**ADC Planning Consultation
Conservation/Design Officer Response**

Application Number	LU/153/17/L & LU/152/17/PL
Address	Friends Meeting House, 23 Church Street, Littlehampton
Description	Alteration and addition to Grade II listed building
Case Officer	Andrew Wood
Date	1 June 2017

PROPOSED SITE PLAN & ROOF PLAN

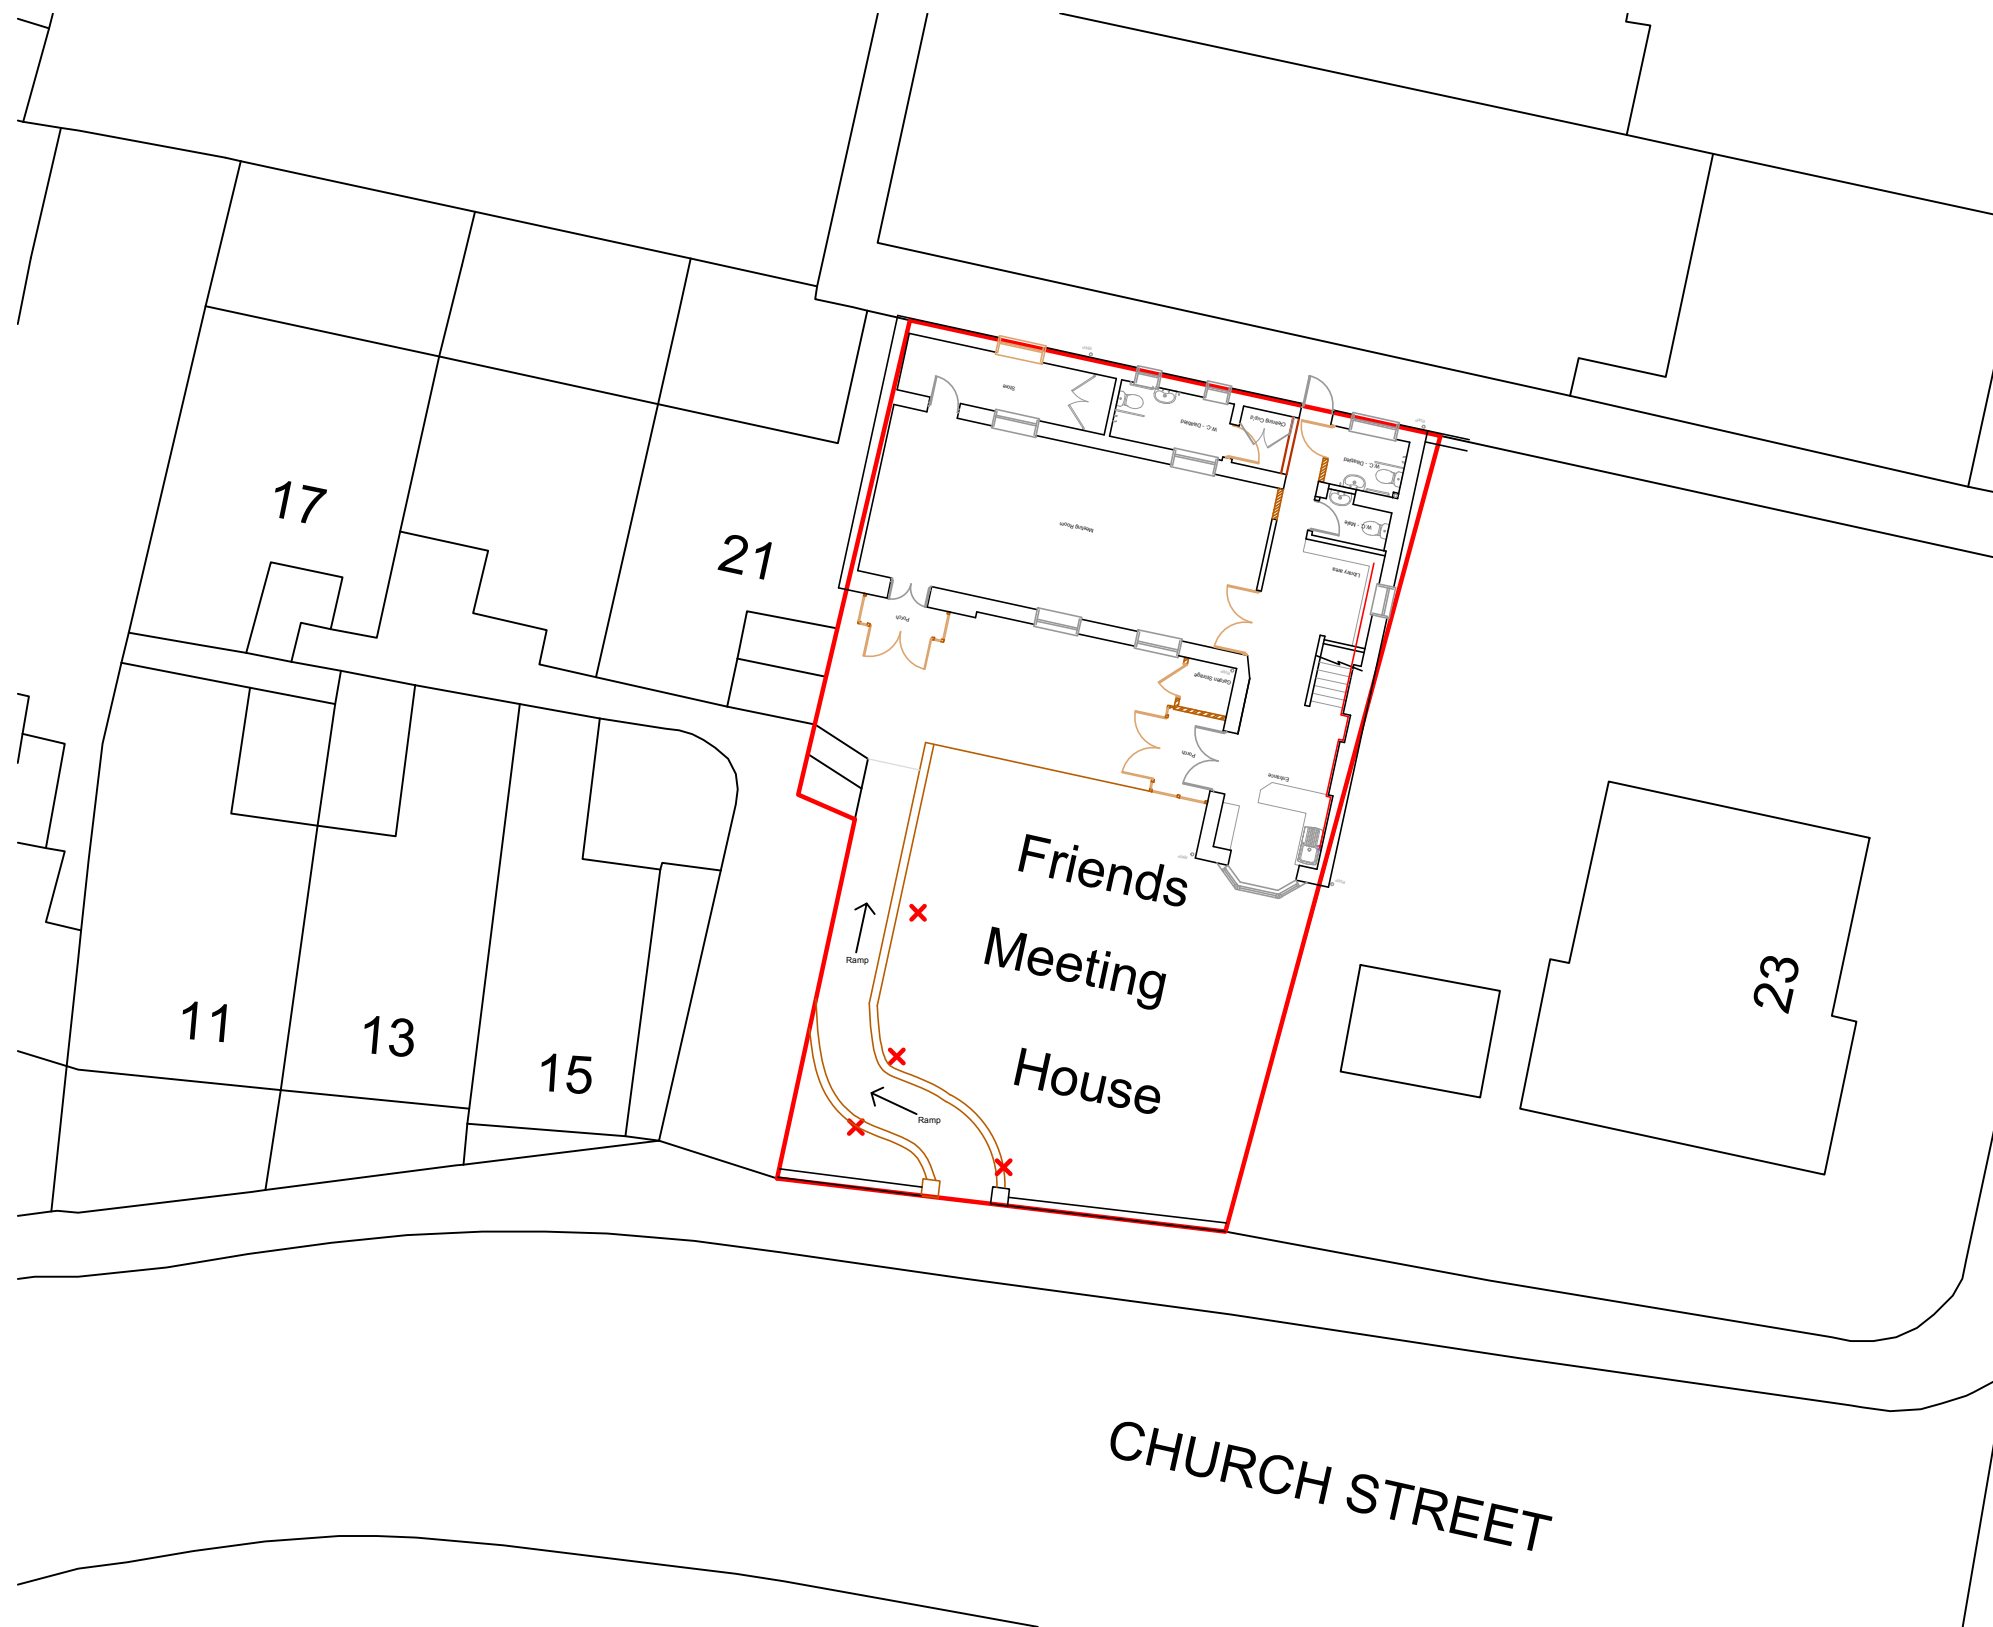
There is no objection in principle to minor adaptations to the building which facilitate disabled access without harming the significance of the heritage asset. However the proposed front porches and the new storeroom clutter the principal elevations, obscure important architectural features and considerably alter the appearance of the building. The new structures result in little material benefit and their intrusive visual presence diminishes the distinctive aesthetic qualities of the heritage asset, thereby harming its significance.

The harm to the aesthetic qualities of the listed building is not mitigated by any improvement in access for disabled users, as the porches do not materially alter the present arrangements. The proposed storeroom is not essential to keeping the building in sustainable use and there is no justification for siting a utilitarian structure in such a prominent location.

PROPOSED ELEVATIONS 1:100

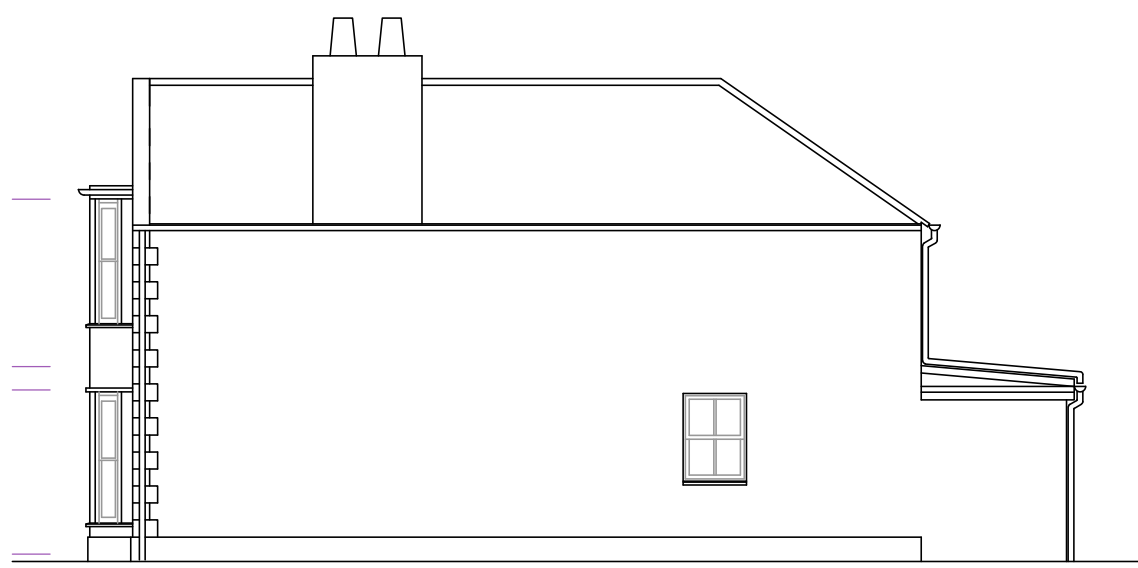
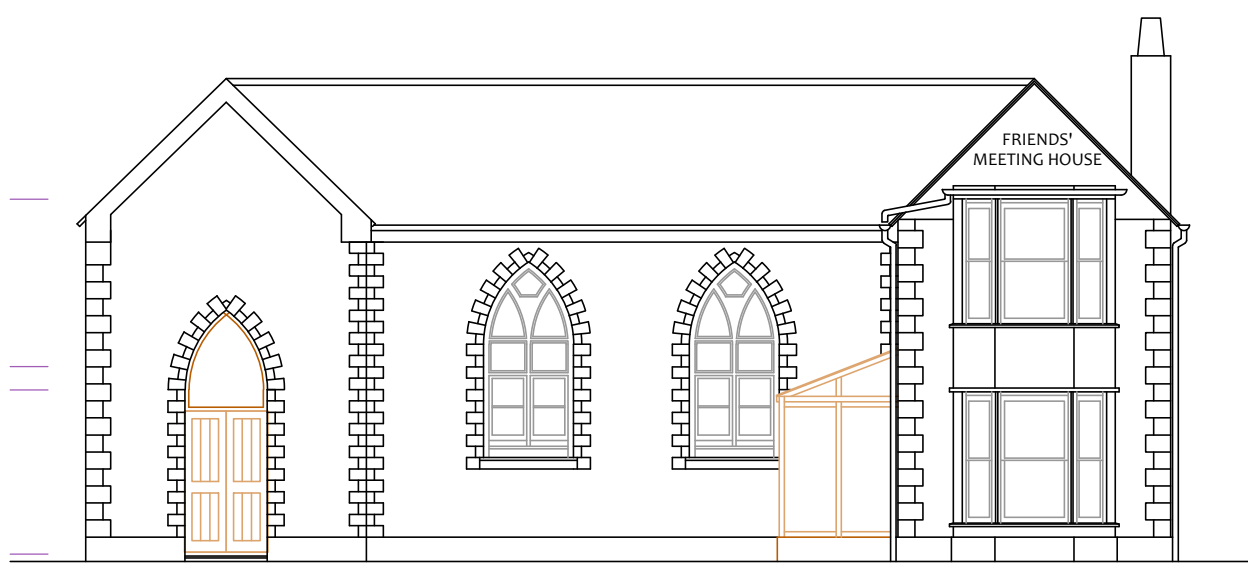
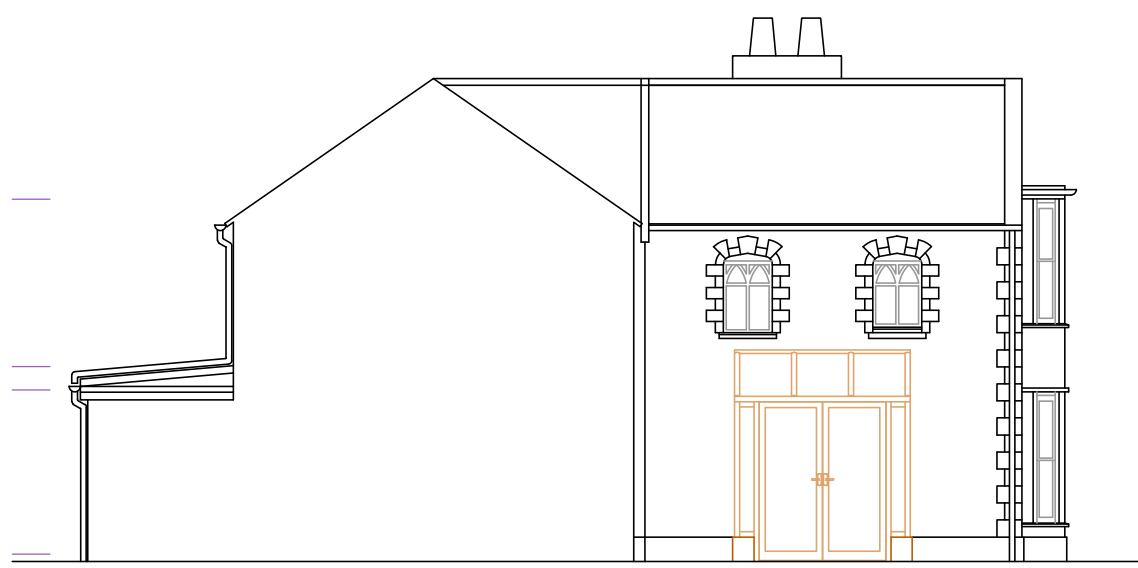
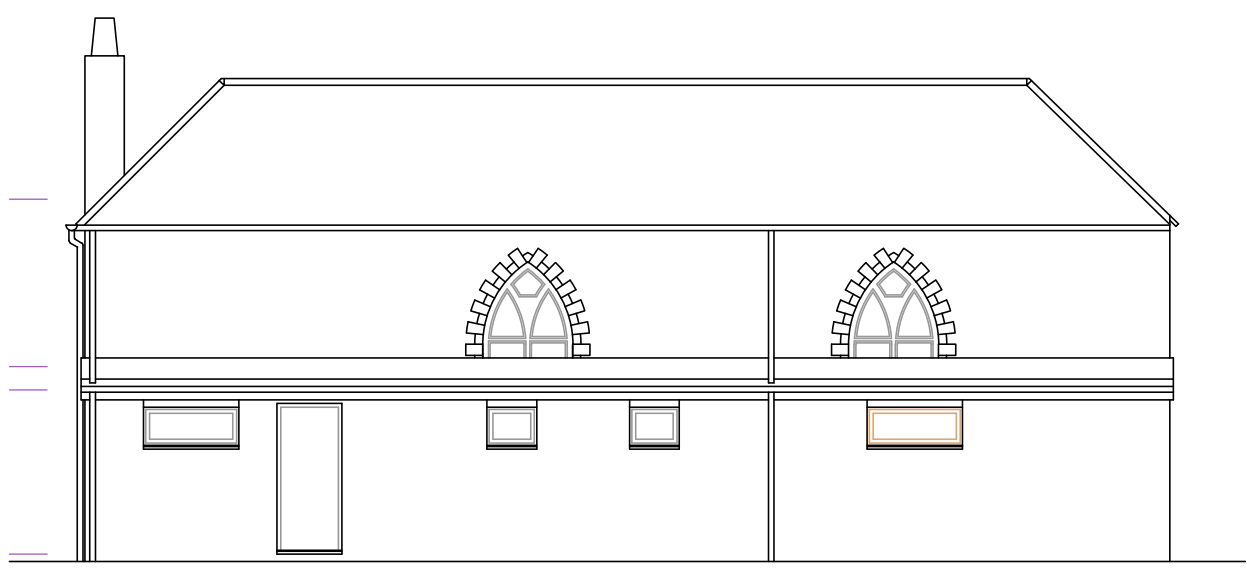
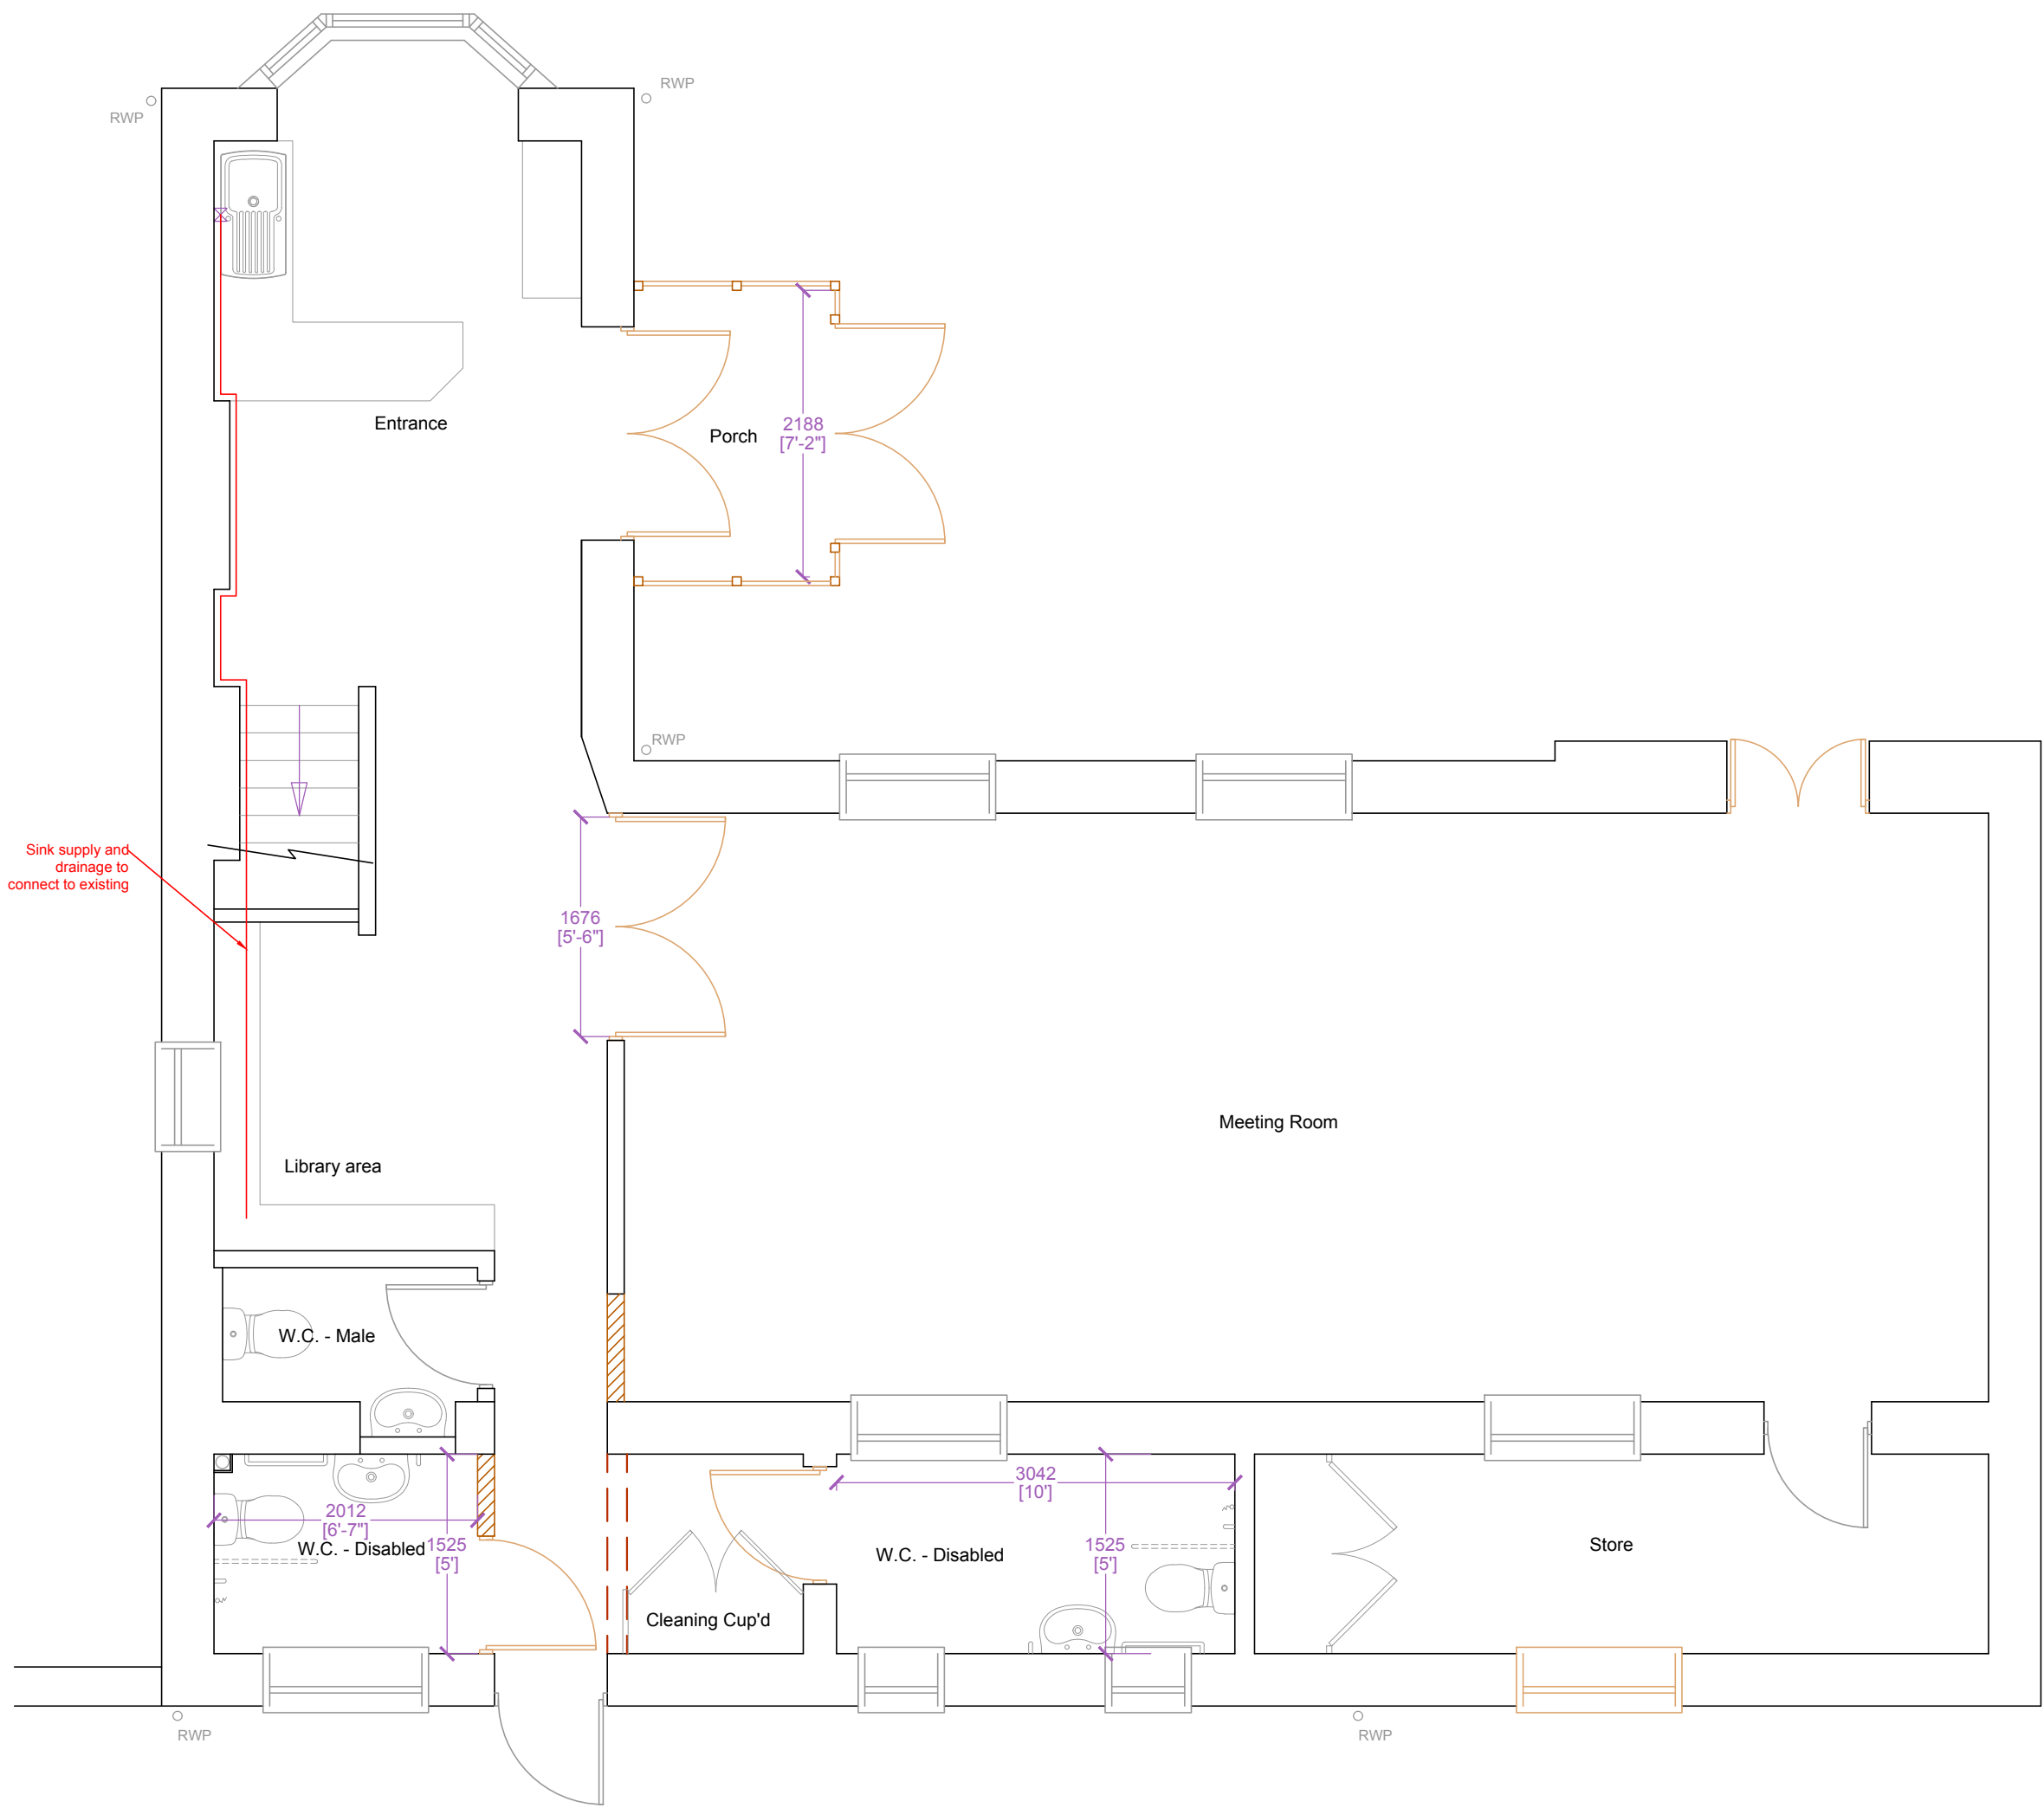
Provided the plumbing for the new sink is attached to the interior surface of the wall and causes no loss of historic fabric, there is no objection to this element of the proposal.

The information provided in support of the work to the interior wall of the main Meeting Room is insufficient to allow a full understanding of its potential impact on the significance of the heritage asset (Ref NPPF para 128).

- Evidence must be provided that the alteration is essential to allow wheelchair access to the room (ie. that a wheelchair cannot pass through the existing door openings)

- An assessment of the significance of the affected fabric must be provided. (ie. whether it is part of the original structure, or later work)
